Application by Highways England for the M25 Junction 28 Project

The Examining Authority's Further Written Questions and requests for information (WQ2)

Issued on Thursday 25 March 2021

Maritime House, Basin Road North, Portslade, Brighton, BN41 1WR  
Telephone: 01273 414515      www.redwoodpartnership.co.uk

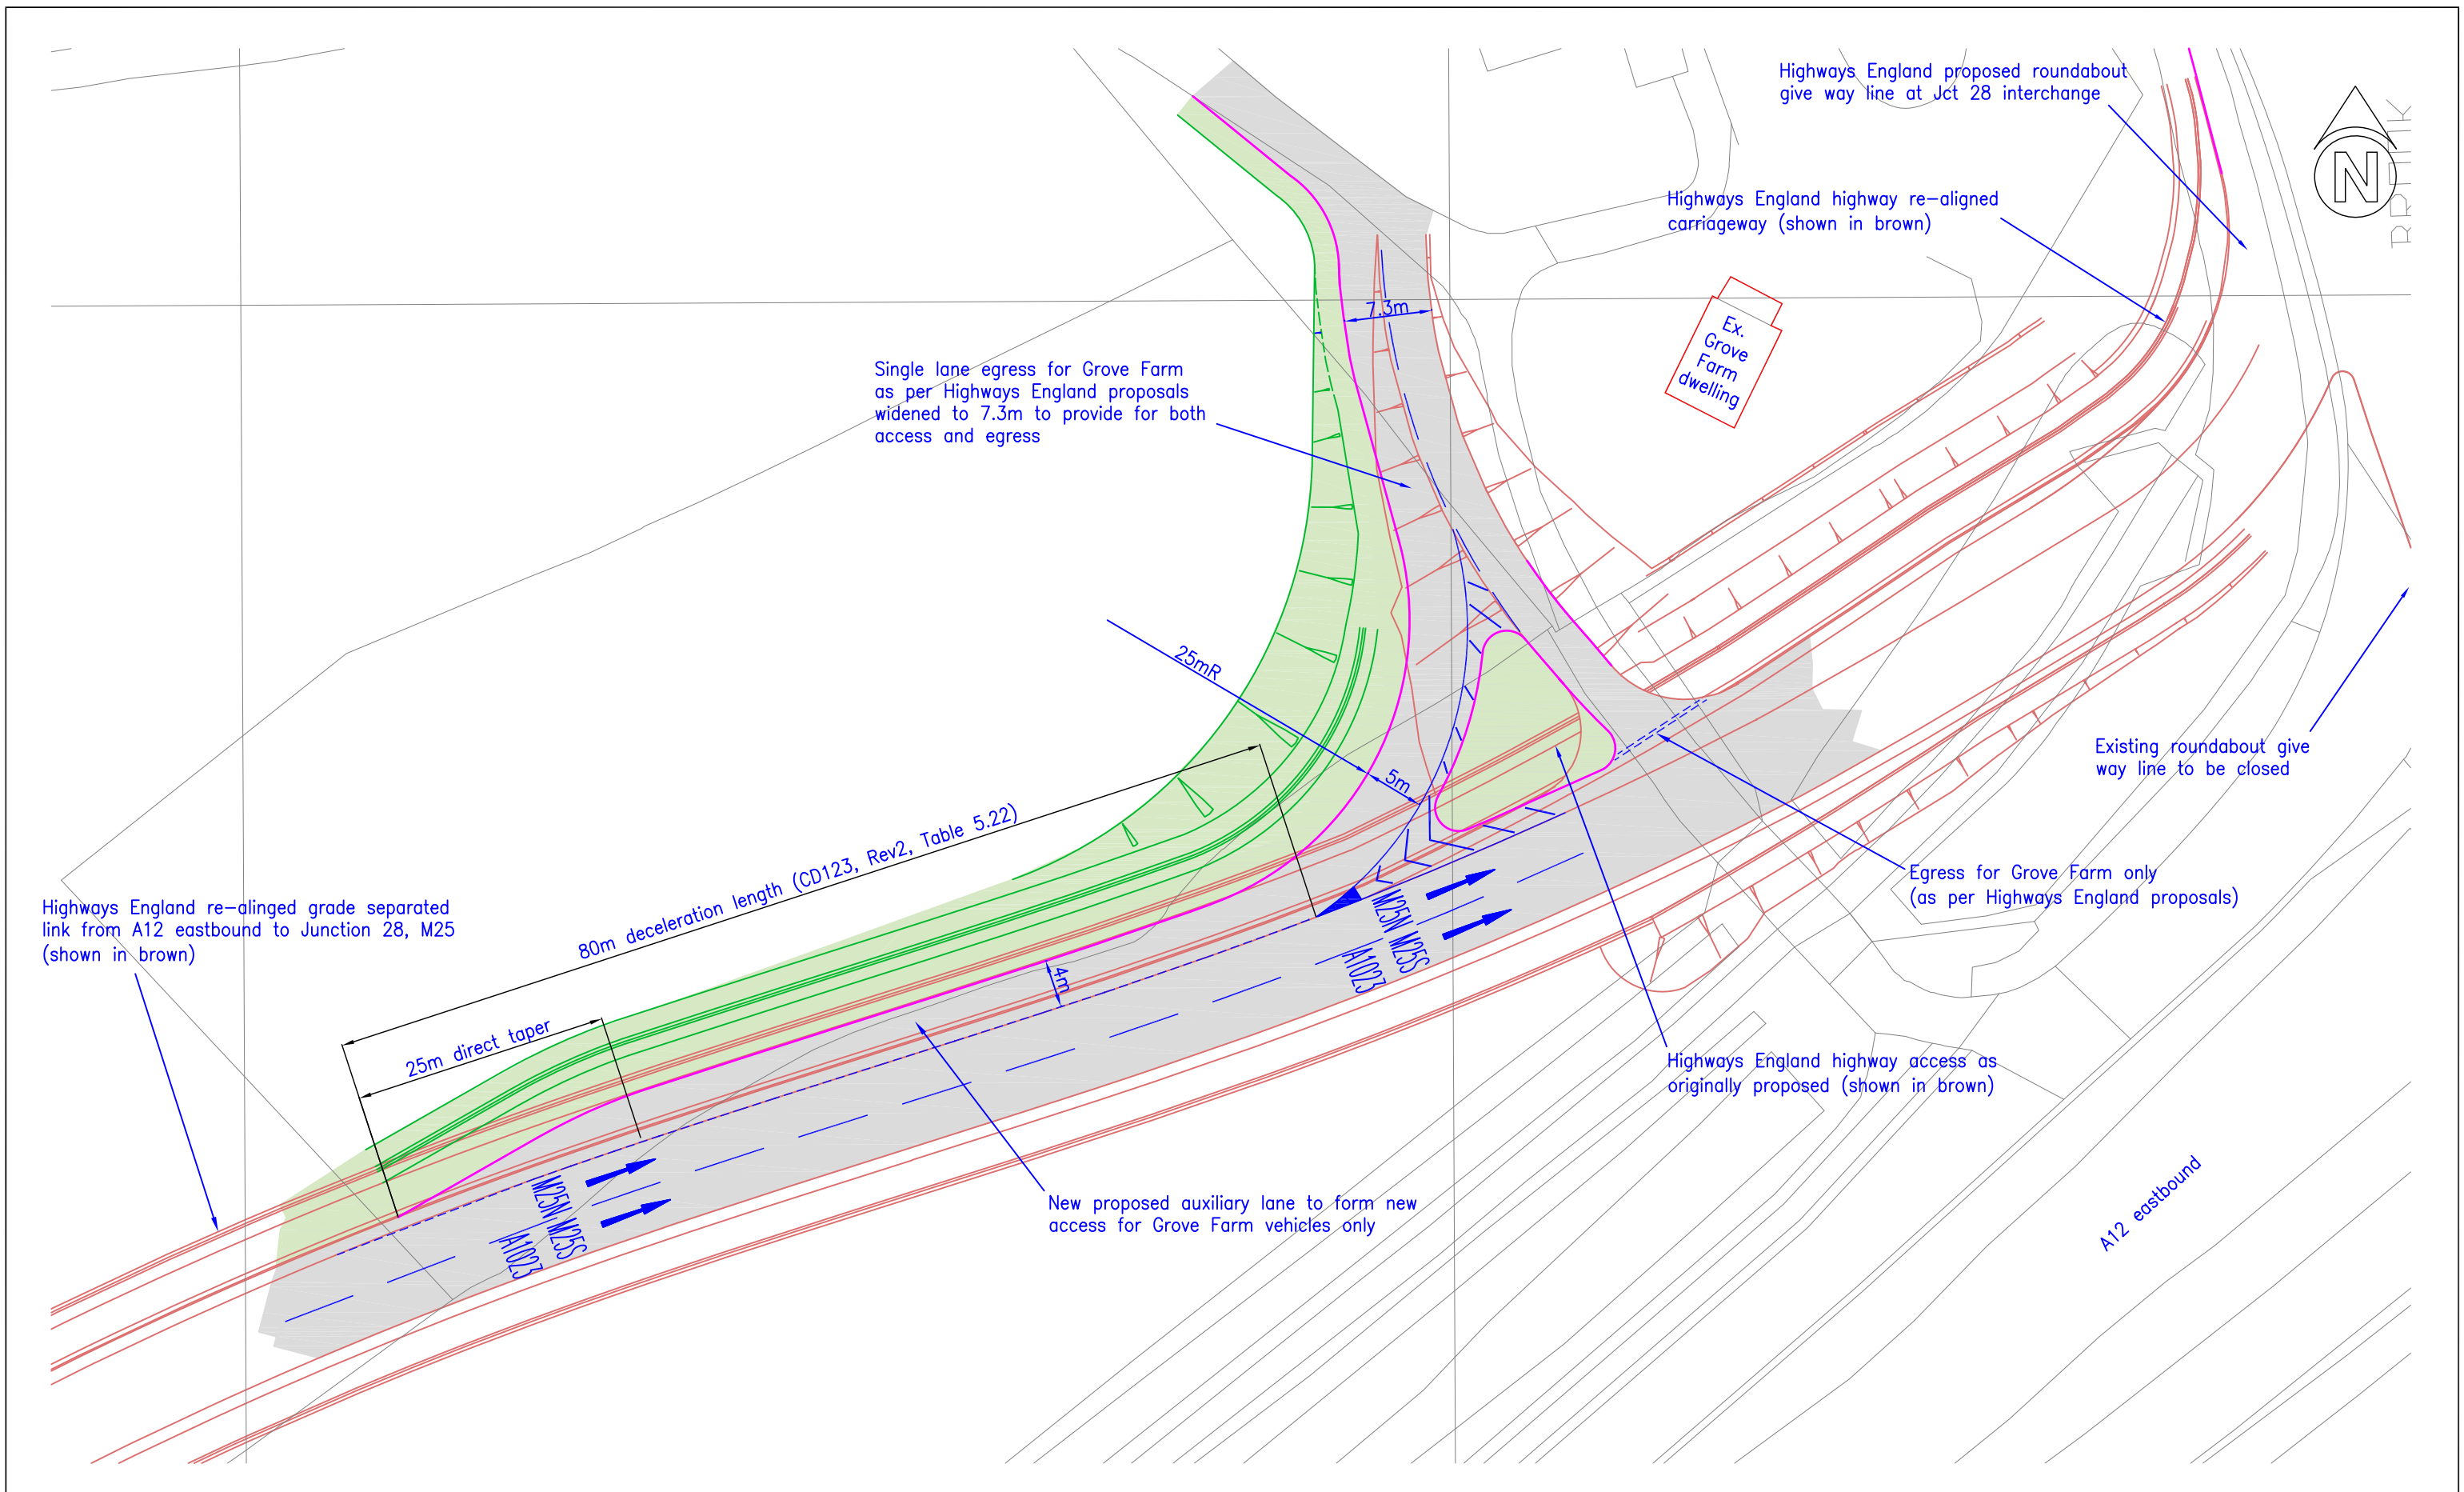
TA 2.3	<i>Proposed Access / Egress at Grove Farm</i> The Applicant	The representatives of Mr & Mrs Jones submitted revised proposals at Deadline 4 [REP4-036] for access / egress to and from their property. Provide comments on these proposals.
